From: [David Kindel](#)
To: [Harmon Rita T.](#)
Subject: RE: 512 Yale
Date: Wednesday, April 20, 2016 2:02:18 PM
Attachments: [image001.png](#)
[image002.png](#)
[image003.png](#)
[512 Yale SE - ALTA Survey.pdf](#)
[15013 -AS101-Layout1 \(2\).pdf](#)
[15013 -AD101-Layout1.pdf](#)

Senior Engineer, Hydrology
COA, Planning Department
505-924-3695

C5 SCHEMATIC SECTION AT TRENCH DRAIN

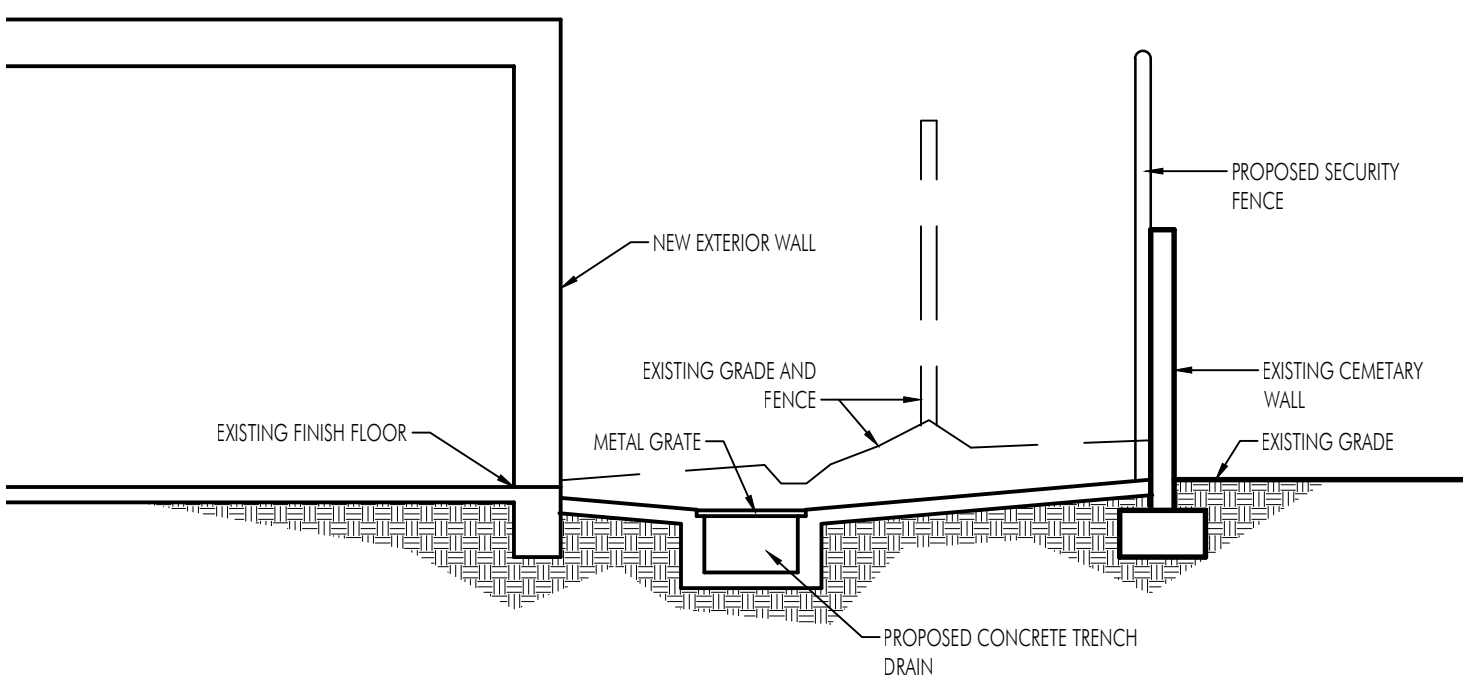
- I cannot tell where the property line is. There are 2 references.
The Property Line for 512 Yale lies right in the middle of the utility easement- The note calling out the CMU wall on cemetery property line should be revised to say "CMU WALL ON CEMETERY PROPERTY"

- What is the meaning of the dash-dot-dash lines? There are 3 lines and it is not clear
DASH DOT LINES REPRESENT SECURITY FENCING ON BOTH PLANS- WE ARE PROPOSING TO MOVE THE EXISTING FENCE ON YALE PROPERTY TO THE CEMETARY WALL TO CUT OFF THE EASEMENT FROM THE ALLEY

A.L.T.A / A.C.S.M. LAND TITLE SURVEY
OF
LOTS 4 AND 5, BLOCK 70
UNIVERSITY HEIGHTS
CITY OF ALBUQUERQUE
BERNALILLO COUNTY, NEW MEXICO
JANUARY, 2013

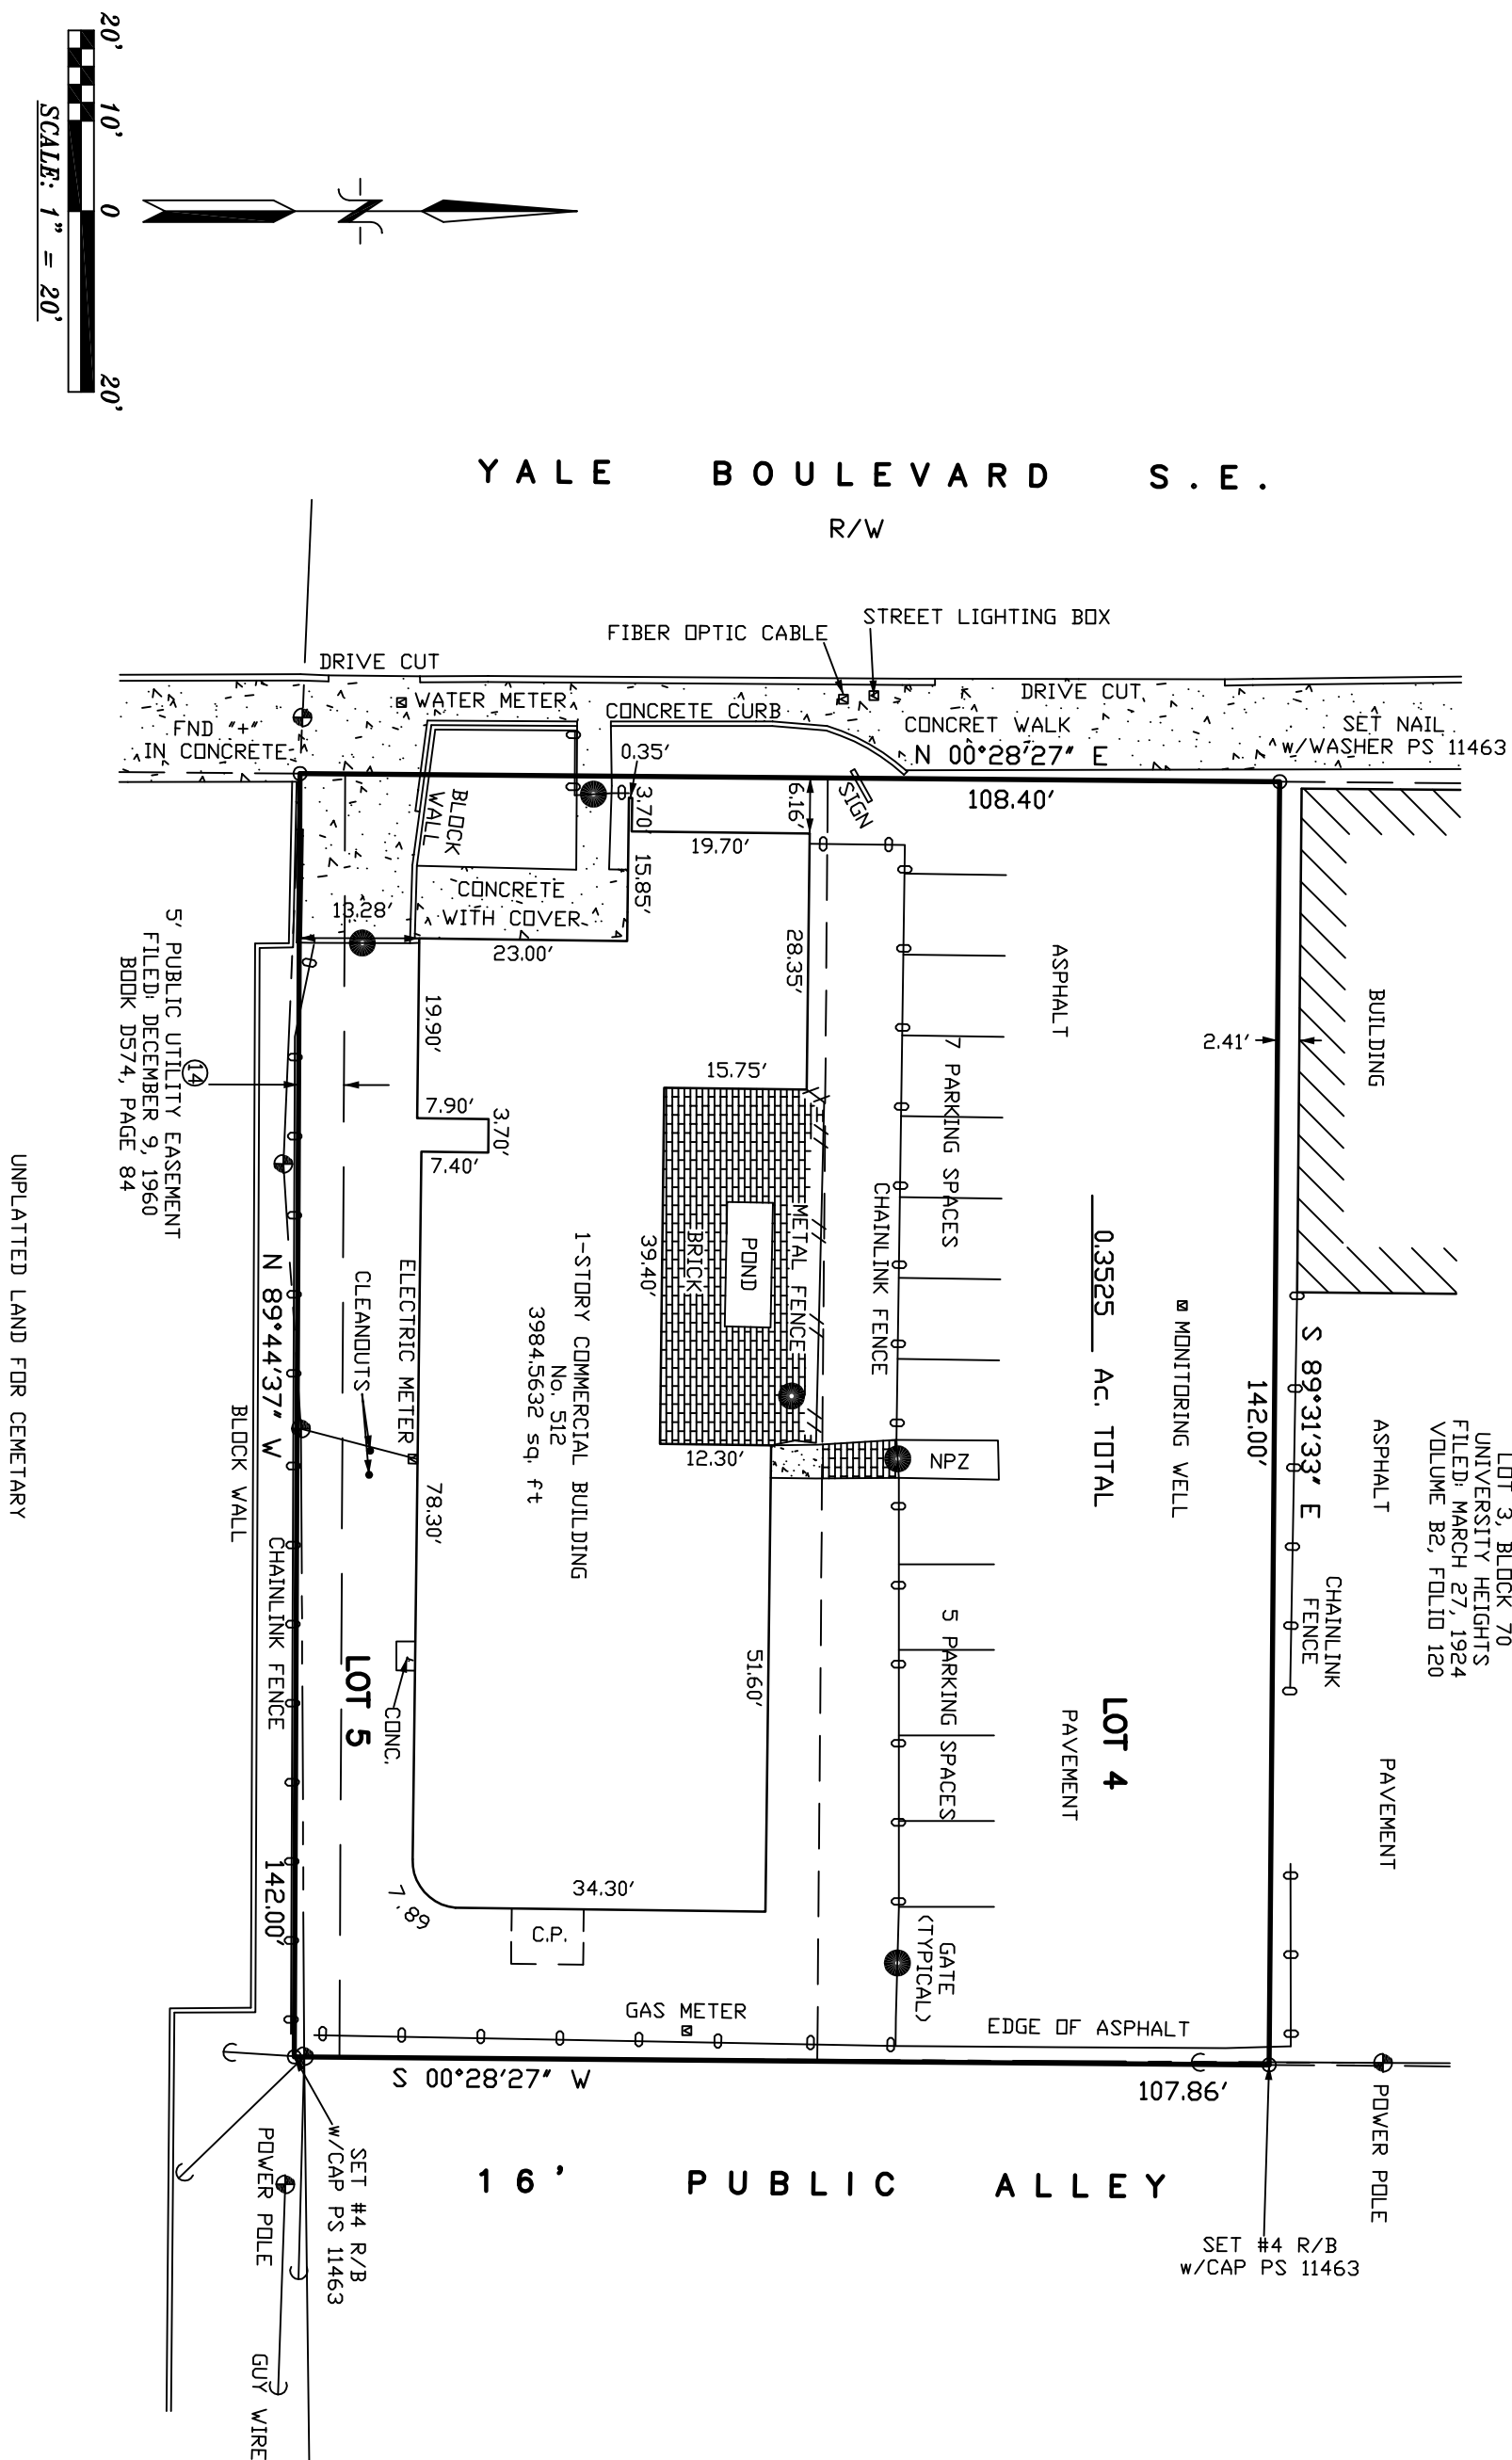
- The Utility easement appears to on property for 512 Yale, is this correct? Provide a plat is possible.
SEE ATTACHED SURVEY – 5' OF THE UTILITY EASEMENT IS ON 512 YALE PROPERTY
